From: Maria Tomalova
Sent: 19 July 2019 10:52
To: Planning.Responses
Subject: FW: BR/63/19/PL, 15-17 Kew Gardens, Bognor Regis
Attachments: 180037_02B_blockplan-A3 SHEET.pdf; 180037_03A_proposedsiteplan-A1 SHEET.pdf; 180037_04A_proposedplansandelevationsP1andP2-A1 SHEET.pdf; 180037_05A_proposedstreetscenes-A1 SHEET.pdf; 180037_07_proposedplansandelevationsP3andP4-A1 SHEET.pdf; 180037_08_proposedplansandelevationsP5andP6-A1 SHEET.pdf

Technical housing standards – nationally described space standard

Title:-
Proposed Floor Plans & Elevations (P5&P6)

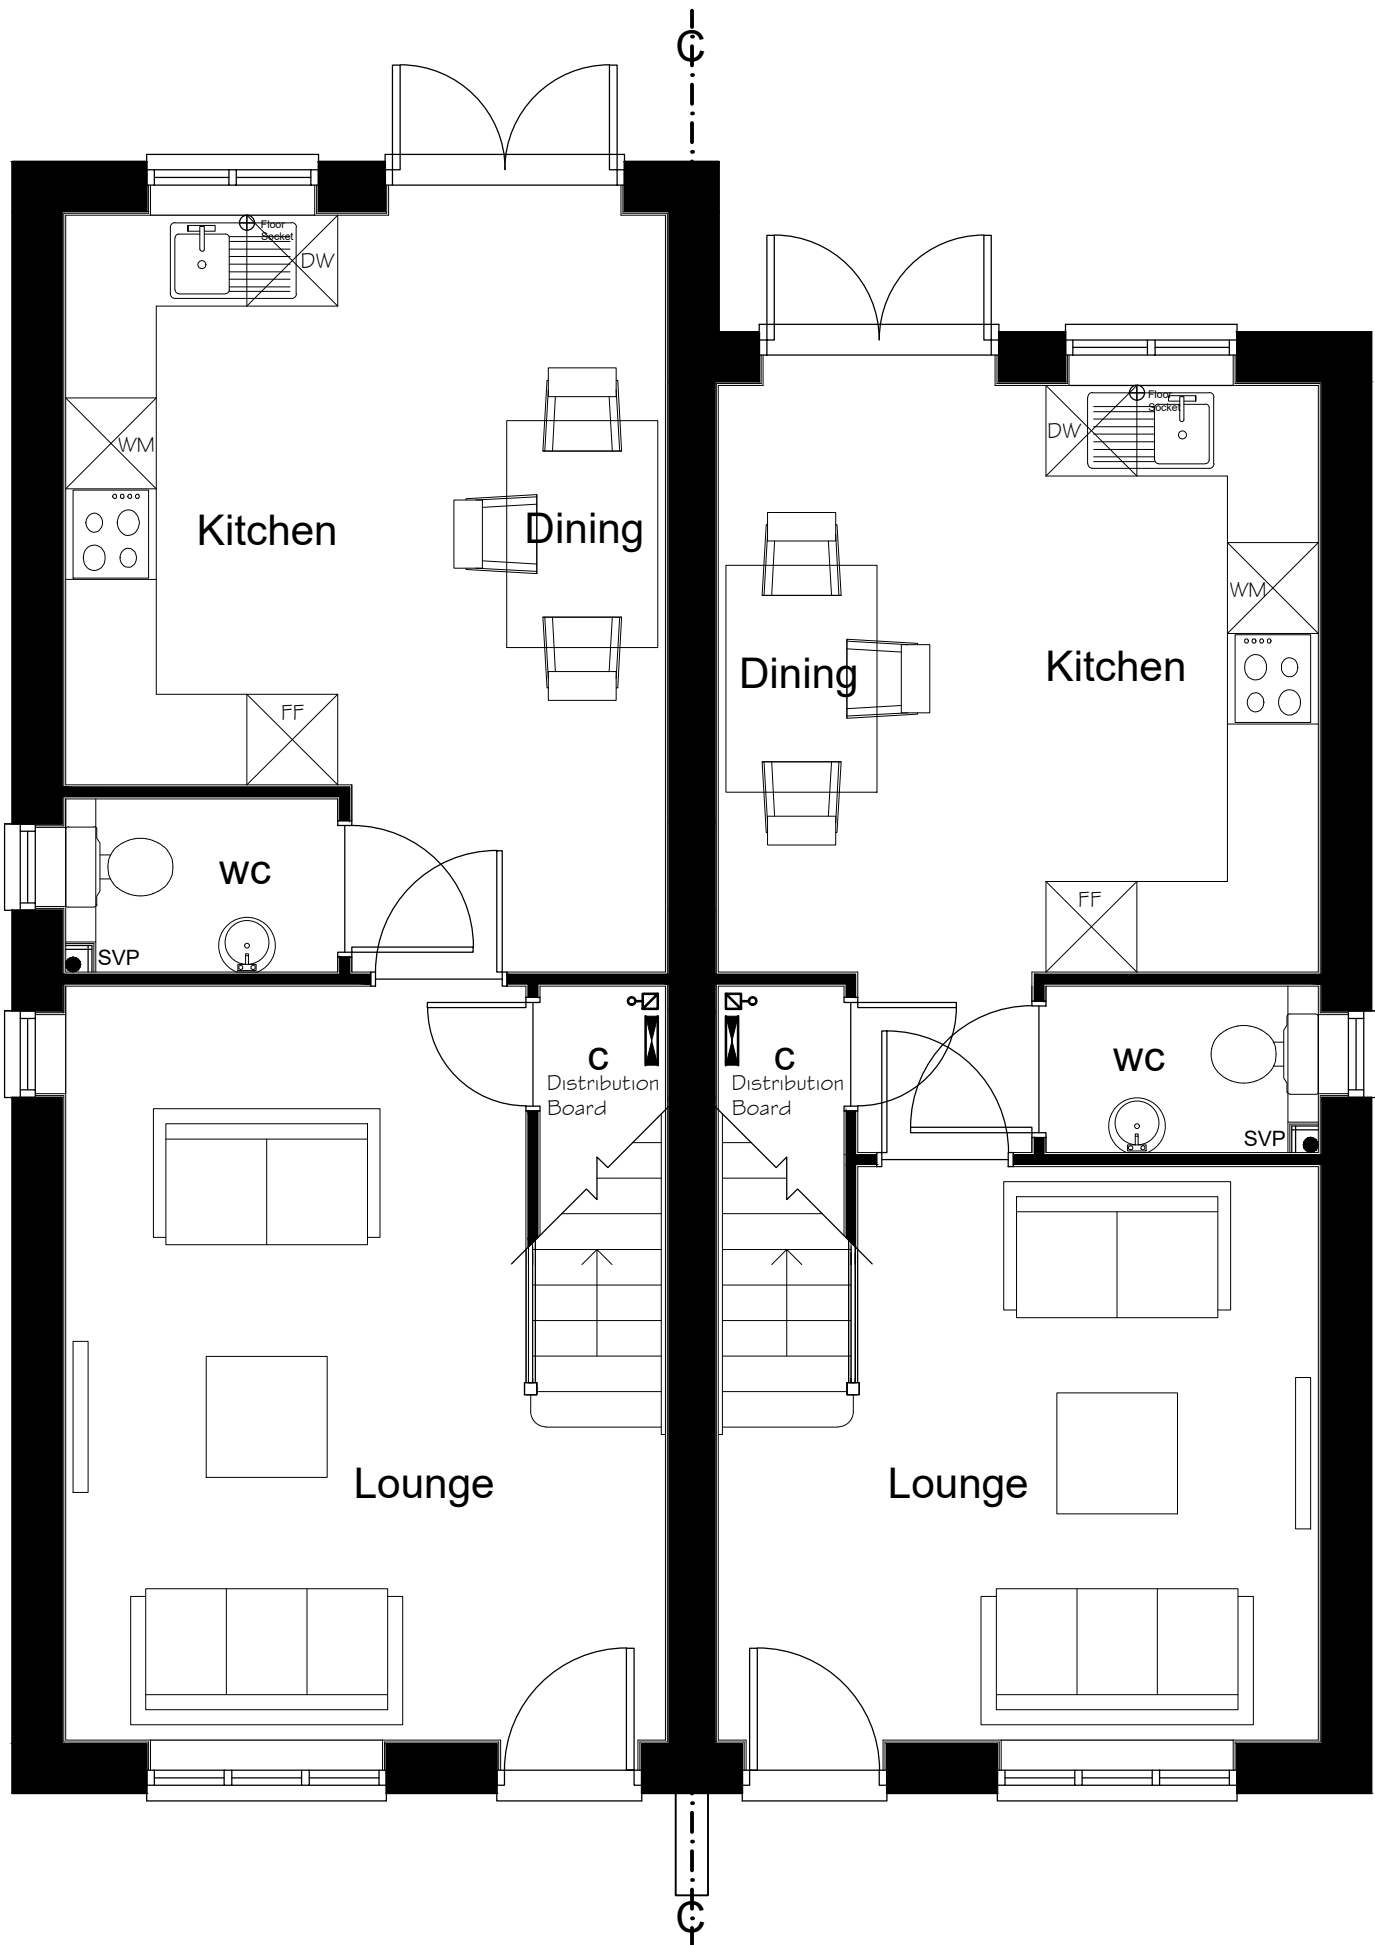
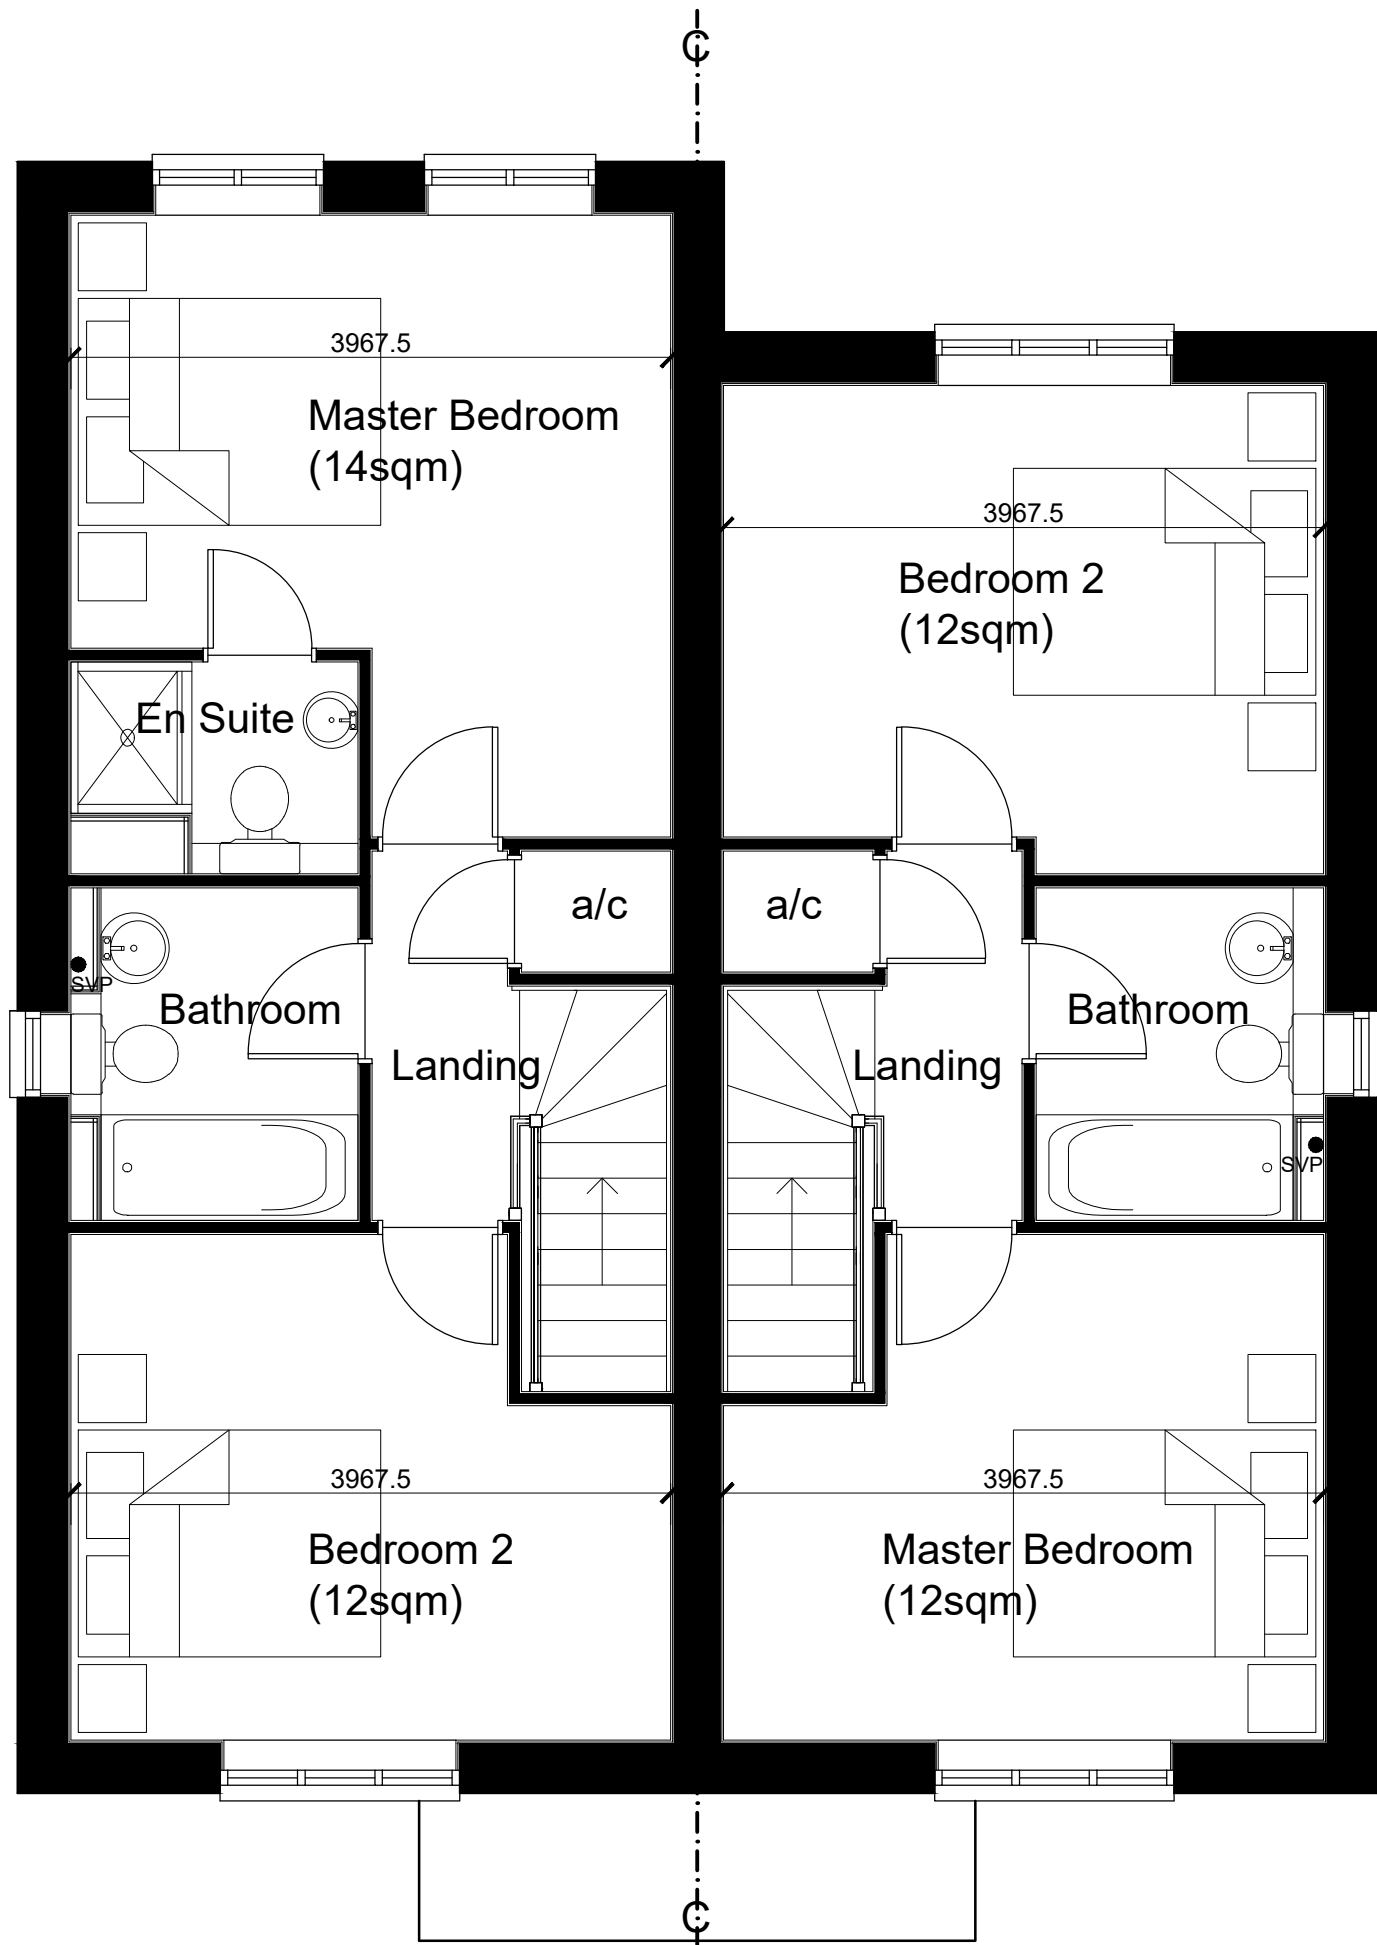
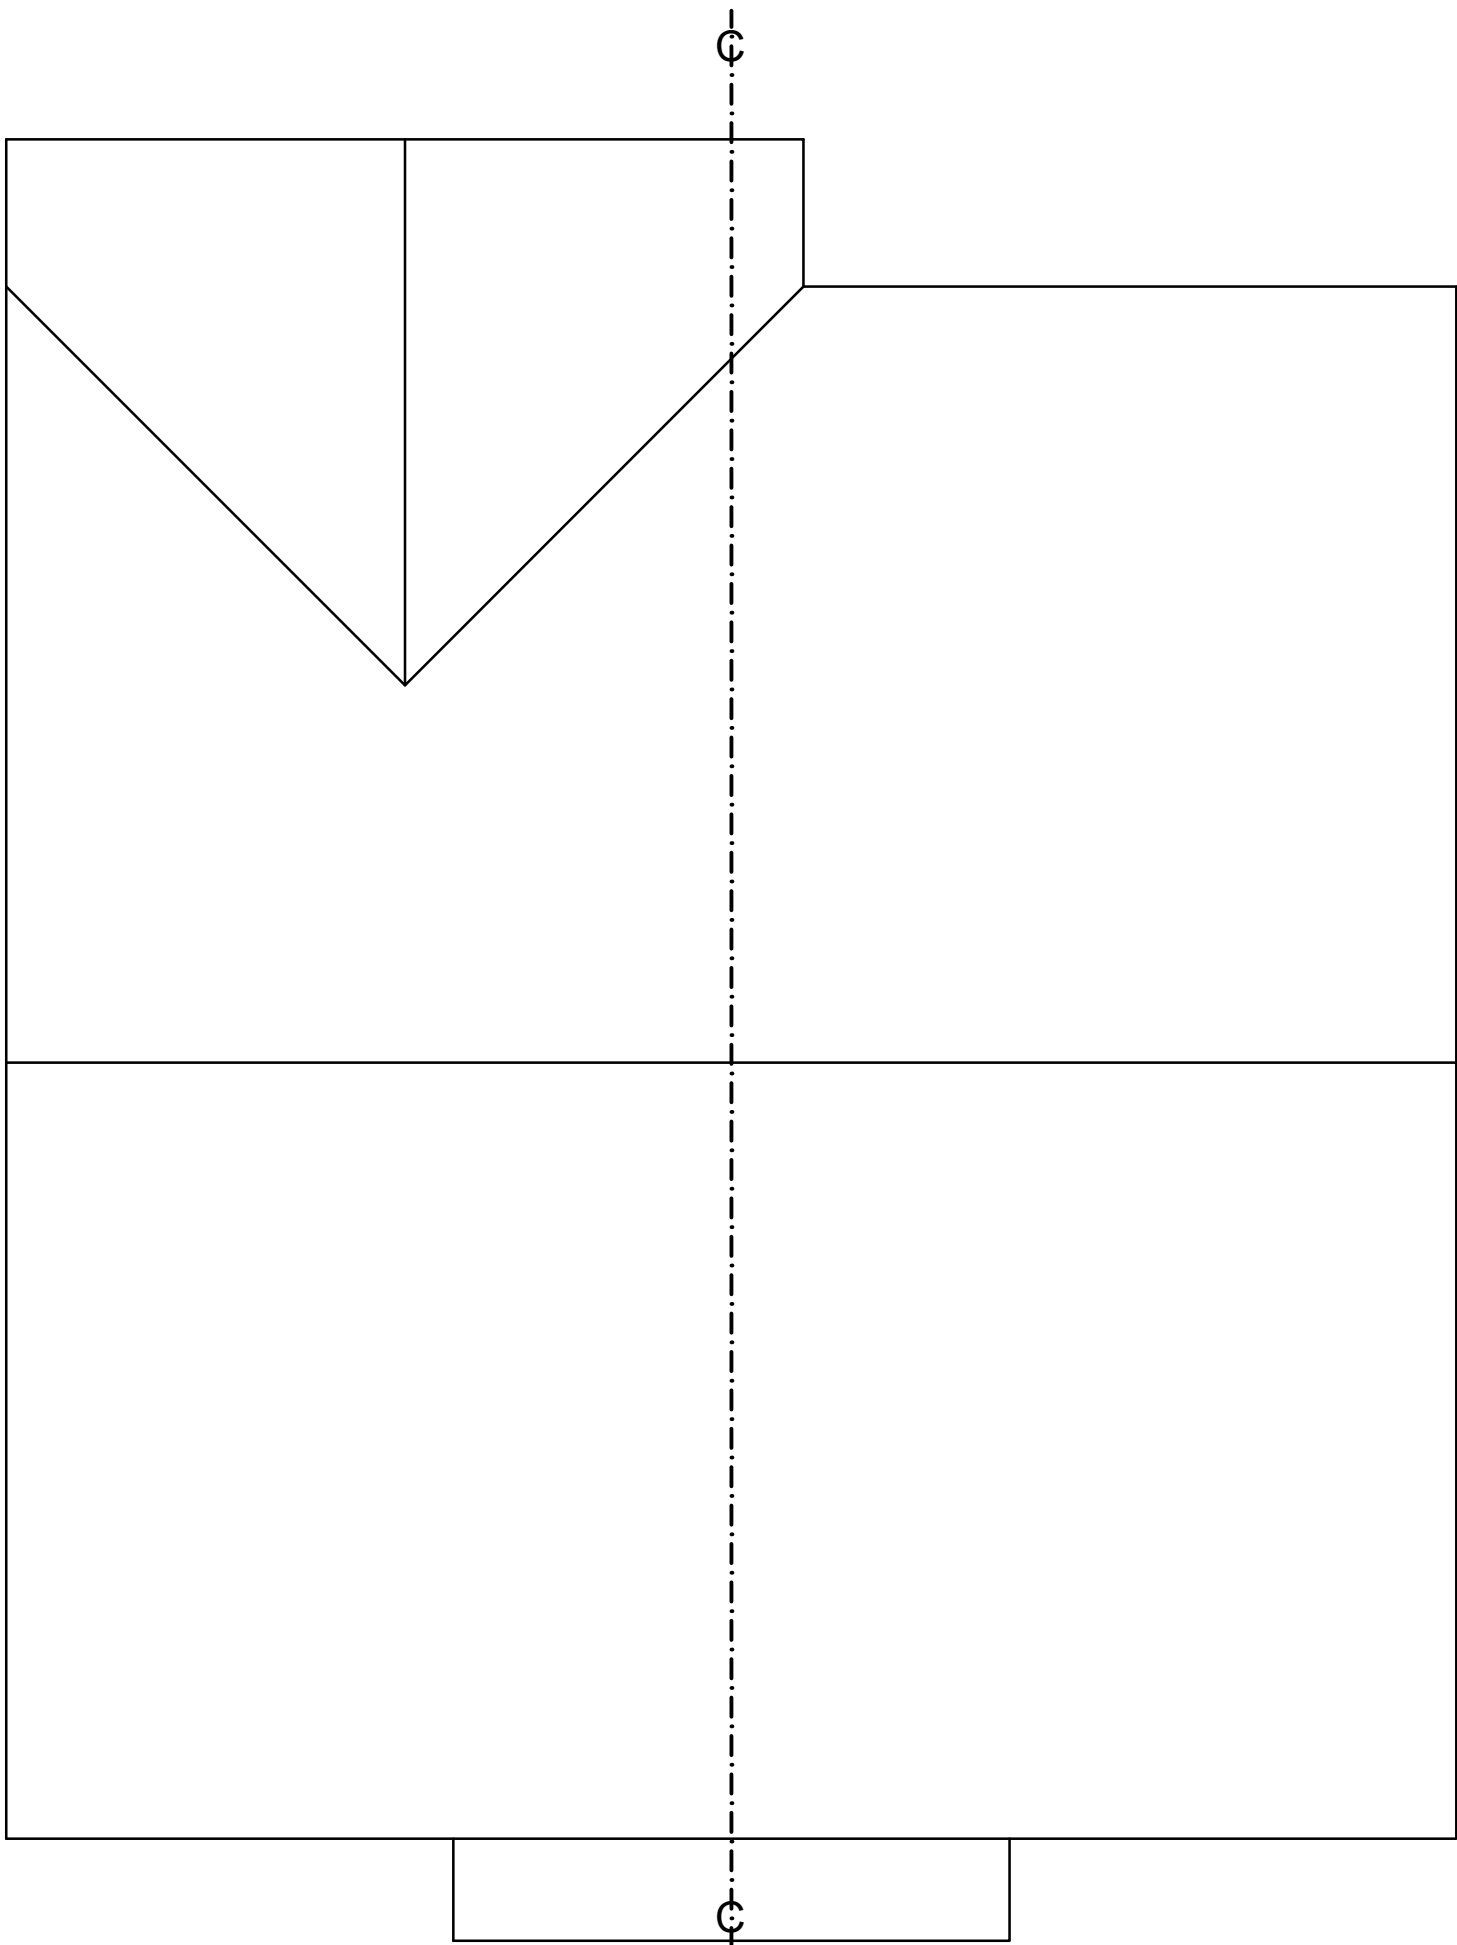
Please see below the min requirement for the floor space.
I am afraid your proposal would not comply with.

- c. in order to provide one bedspace, a single bedroom has a floor area of at least 7.5m² and is at least 2.15m wide
- d. in order to provide two bedspaces, a double (or twin bedroom) has a floor area of at least 11.5m²
- e. one double (or twin bedroom) is at least 2.75m wide and every other double (or twin) bedroom is at least 2.55m wide

2bed , 2storey dwellings

min 79 square metres

It is rather difficult to comment your drawings, since I do not have a tool to measure it on the screen
And I am not sure the size of some bedroom comply with the standard (min width 2.15m, min floor space for 1 bed
7.5 square metres.

I confirm that plots 1 and 6 are now 2 bed 3 person houses at 72sqm. Plots 2 and 5 are now 2 bed 4 person houses at 81sqm. Plots 3 and 4 are now 3 bed 4 person houses at 87sqm. All the bedroom areas and widths now all comply. On this basis all units now comply with the standards.
